Consultation, 20/01257/OUT Farlington Water Treatment Works

Thank you for your consultation. I would draw your attention to the Heritage Statement submitted with the planning application, which I would not endorse to you. It has, in my opinion, two short comings. In the first instance the Heritage Statement is based on the archaeological information held within the Hampshire HER. However the site sits within Portsmouth City and its more immediate location is addressed by the Portsmouth HER which appears not to have been consulted. The Portsmouth HER records an archaeological evaluation associated with the construction of Farlington Reservoir (EMP49). I understand this potentially suggests the presence of Bronze Age burial activity. In consequence the archaeological potential of the area is more complex than presented. The second is that the Heritage Statement acknowledges the impact of temporary compounds, but does not describe those impacts, nor their archaeological implications which undermines the Heritage Statement conclusion that no further archaeological work is required.

1 : 750  
Proposed Site Plan

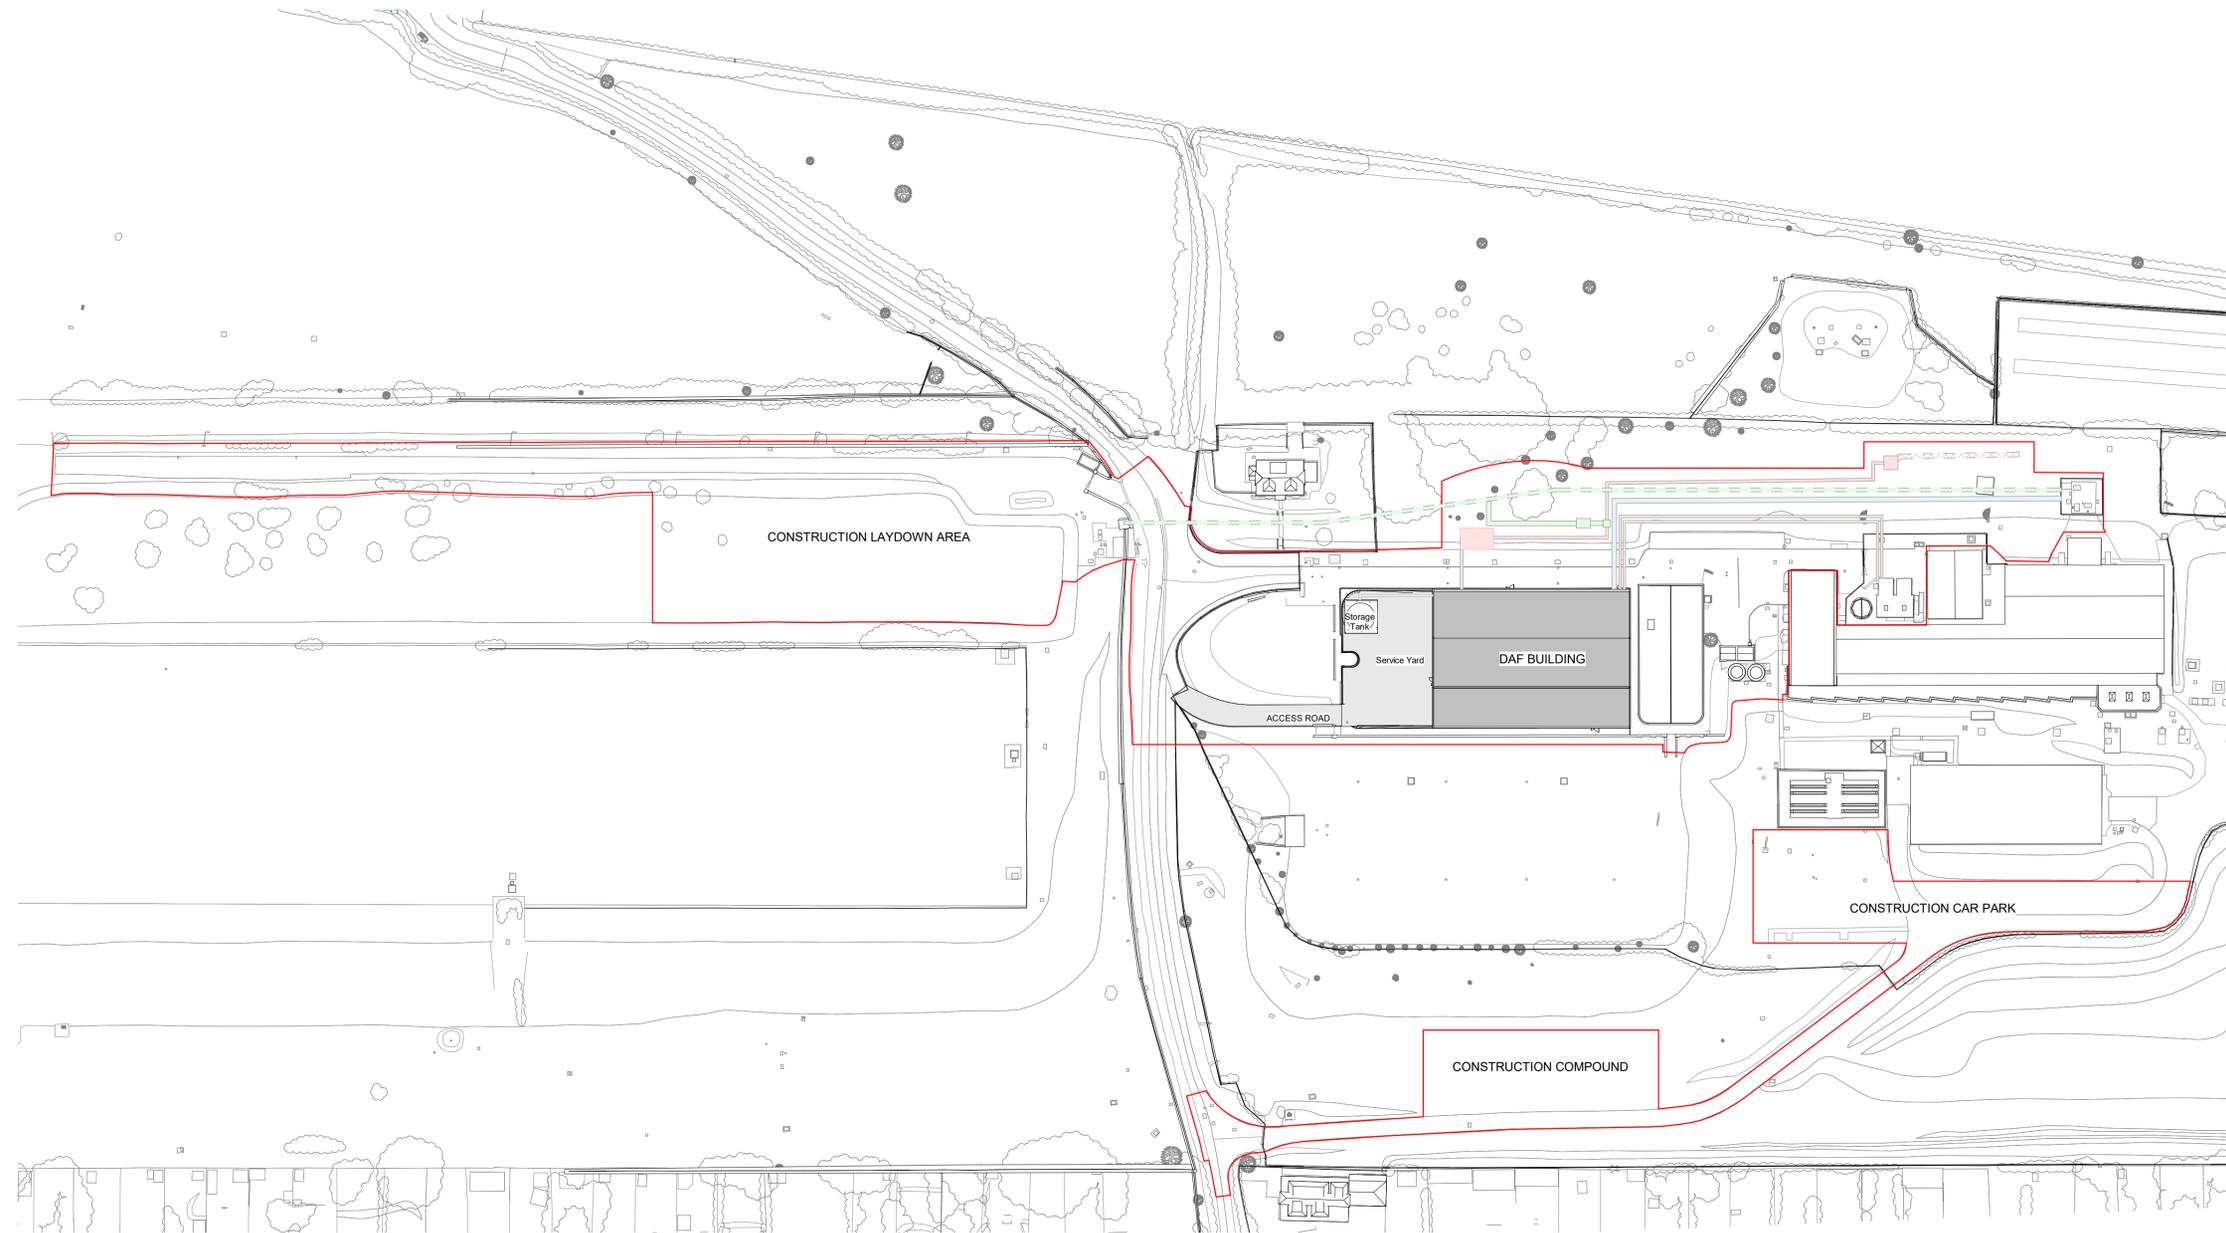
Section 6 states "Impacts may arise from temporary enabling works associated with the construction ..." and the submitted site plan shows a construction laydown area to the north west, a construction compound to the south and a construction car park to the south east. These all appear to be previously undeveloped areas of the site. The assertion that they have been impacted by 20th century development (section 5.1) needs to be substantiated if to be given any weight.

As a consequence section 7.2. Recommendations states " Given the limited impacts, no further works are recommended, as mitigation is not needed." I cannot endorse this conclusion. There appear to be at least three construction related impacts in open areas of the site not apparently previously truncated by 20th century development. The archaeological implications of these impacts needs to be assessed.

I recommend that an archaeological condition is attached to any planning permission issued to secure appropriate archaeological mitigation, the nature of this yet to be described in light of the reassessment of the archaeological implications of development.
